City of Albuquerque

RE: REVISED DRAINAGE PLAN FOR AN ADDITION TO MARTINEZ SHOP
(L-14/D28) RECEIVED FEBRUARY 17, 1989 WITH AN ENGINEER'S
STAMP DATED FEBRUARY 17, 1989

RE: REVISED DRAINAGE PLAN FOR AN ADDITION TO MARTINEZ SHOP
(L-14/D28) RECEIVED JANUARY 24, 1989 WITH AN ENGINEER'S
STAMP DATED JANUARY 26, 1989

GRADING & DRAINAGE PLAN			
MARTINEZ WAREHOUSE COMPLEX			
		D. MARK GOODWIN & ASSOCIATES, P.A. CONSULTING ENGINEERS P.O. BOX 21307 ALBUQUERQUE, NEW MEXICO 87154 (505) 265-0905	
Designed: TOB	Drawn: MB	Checked: MG	Sheet C1 of 1
Scale: 1"=20'		Date: 2-89

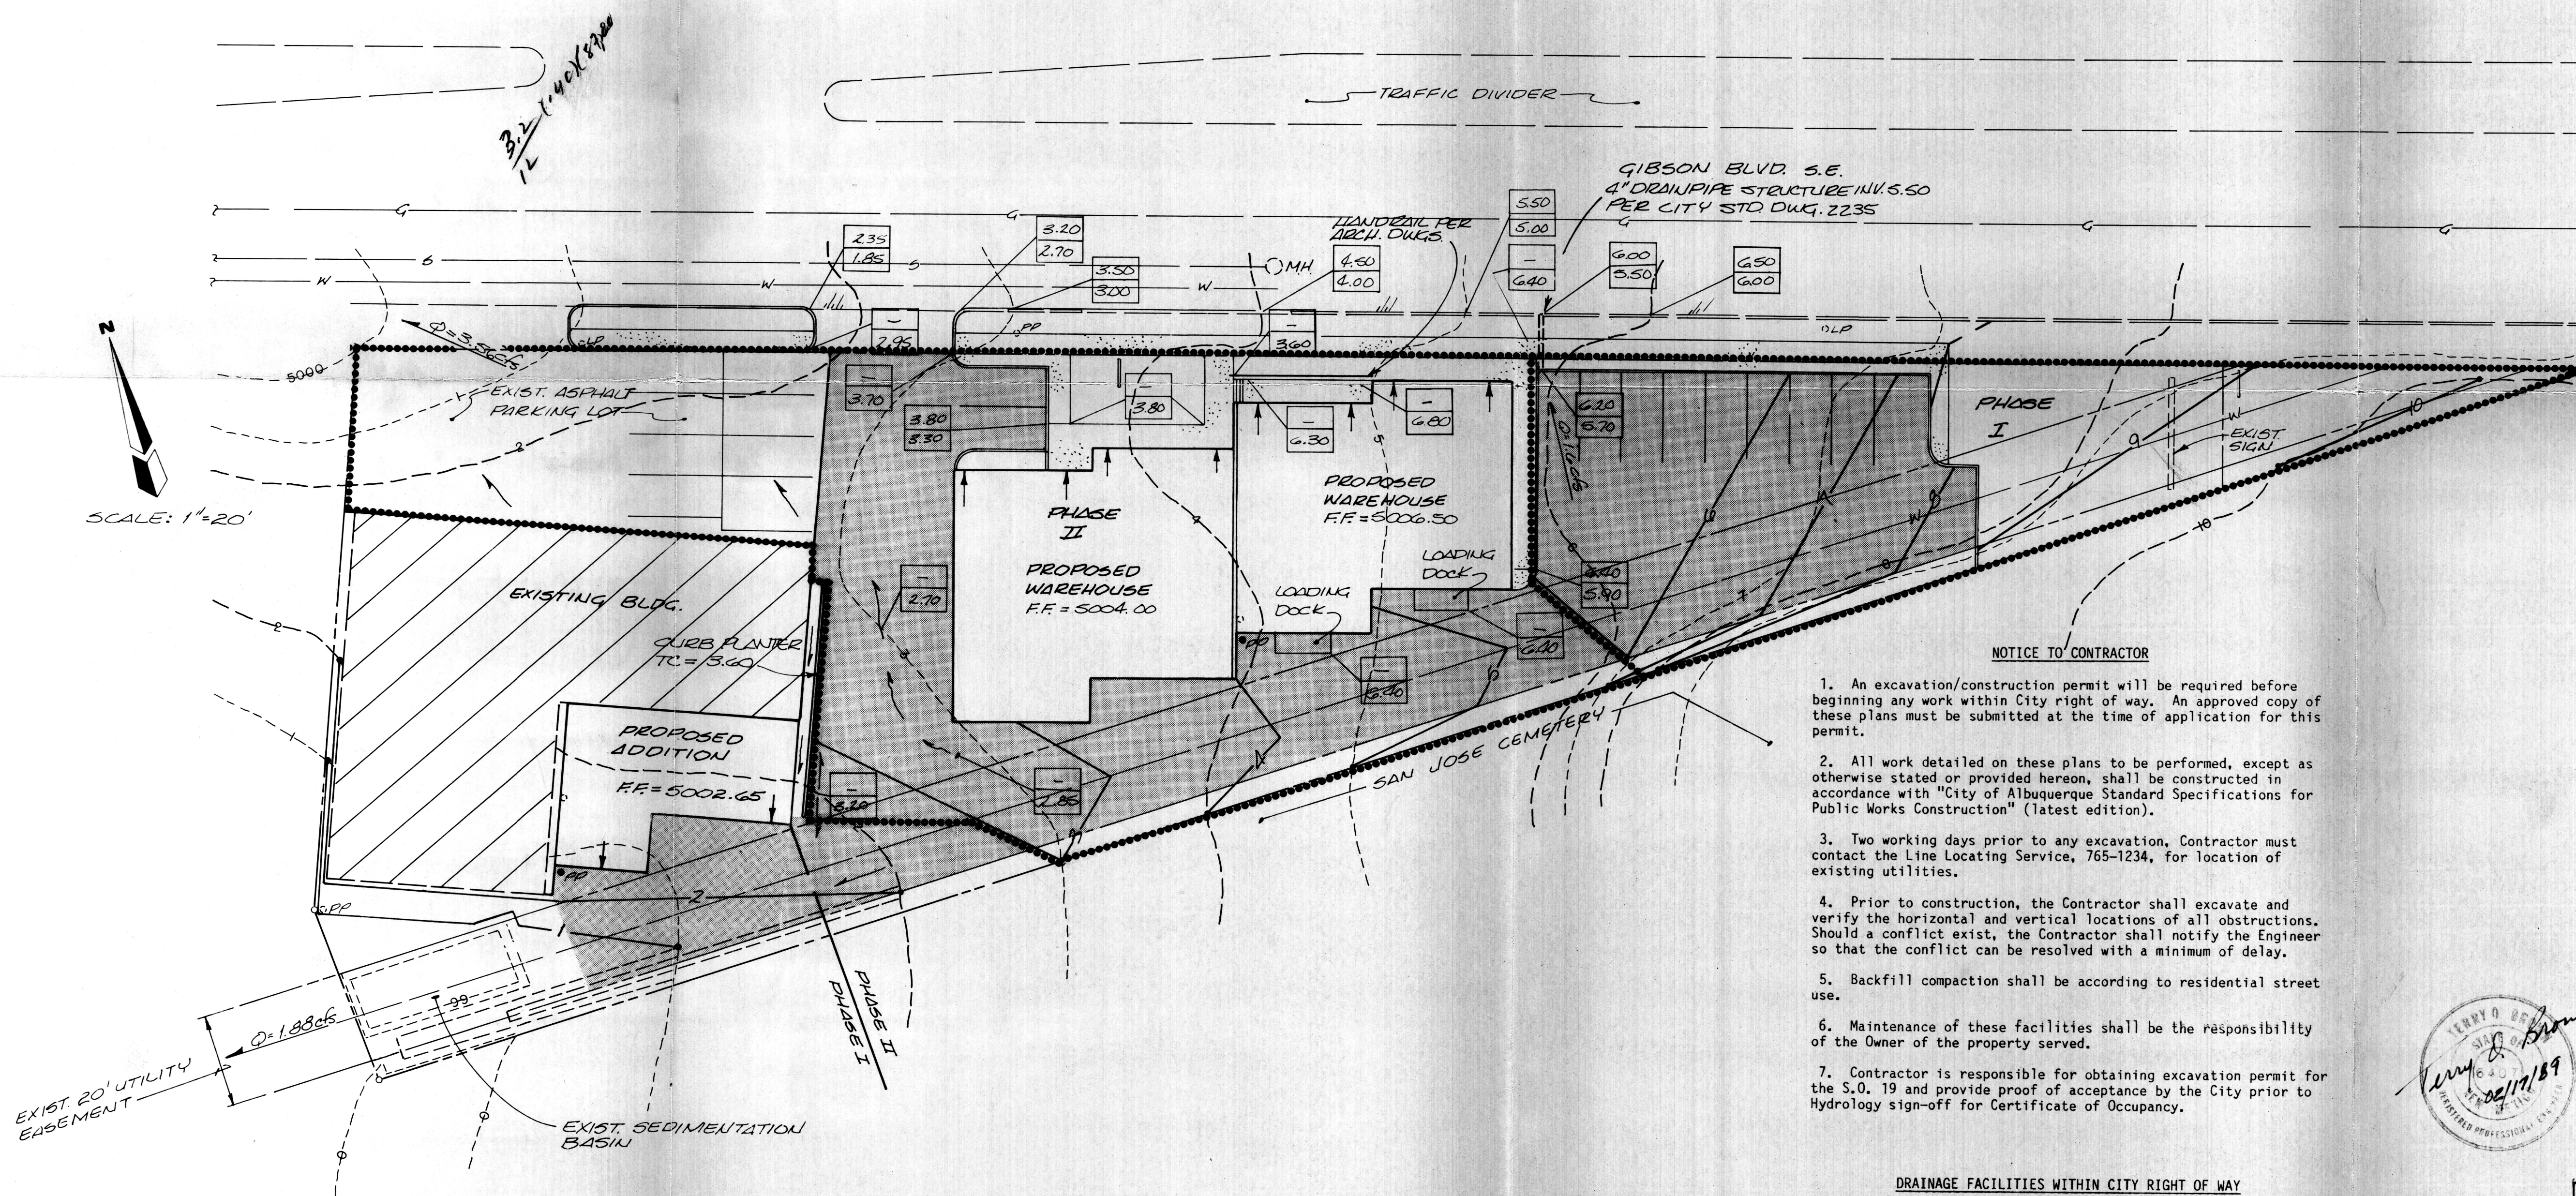
Please be advised that no developed runoff is allowed to cross the public right of way but through an approved drive pad. Therefore, it would be beneficial if all the proposed roof drains be interconnected and routed towards the asphalt parking area.

1. A field inspection has revealed that there is no guarantee that the proposed runoff being routed towards the Torreon Right-of-Way will ever reach Edith Boulevard. Distance seems to be more than 200 L.F. Therefore, it is recommended that all developed runoff be disposed into Gibson Boulevard.
2. You will need to show the Top of Curb and flow line elevations on Gibson Boulevard.
3. Your proposed 4" PVC drain lines will need to be routed directly onto the Gibson Right-of-Way. We cannot allow runoff between the proposed sidewalk and the curb and gutter.
4. Your existing contours indicate you may have some off-site flows entering from the cemetery.
5. Your plan indicated 3.99 cfs release points at two different locations. Where did the 3.99 cfs come from?

6. It may be beneficial to route all the developed runoff to the southwest corner of property into a ponding area designed to hold the 100 volume and then pump it out into Gibson Boulevard.

1. To the extent feasible, I have re-routed the proposed developed runoff to discharge onto Gibson Boulevard. A relatively minor runoff rate still enters Torreon as approved on the drainage plan submitted in December 1988.
2. Top of curb and flowline elevations are now shown on the plan.
3. The proposed 4" PVC drain now carries the discharge to Gibson Boulevard. Additionally, the necessary S.O. 19 language and signature blocks are shown on the plan.
4. Our field investigation indicated that offsite flows entering this site from the south are negligible.
5. Calculations for determinations of runoff rates are shown at the top of the plan sheet.
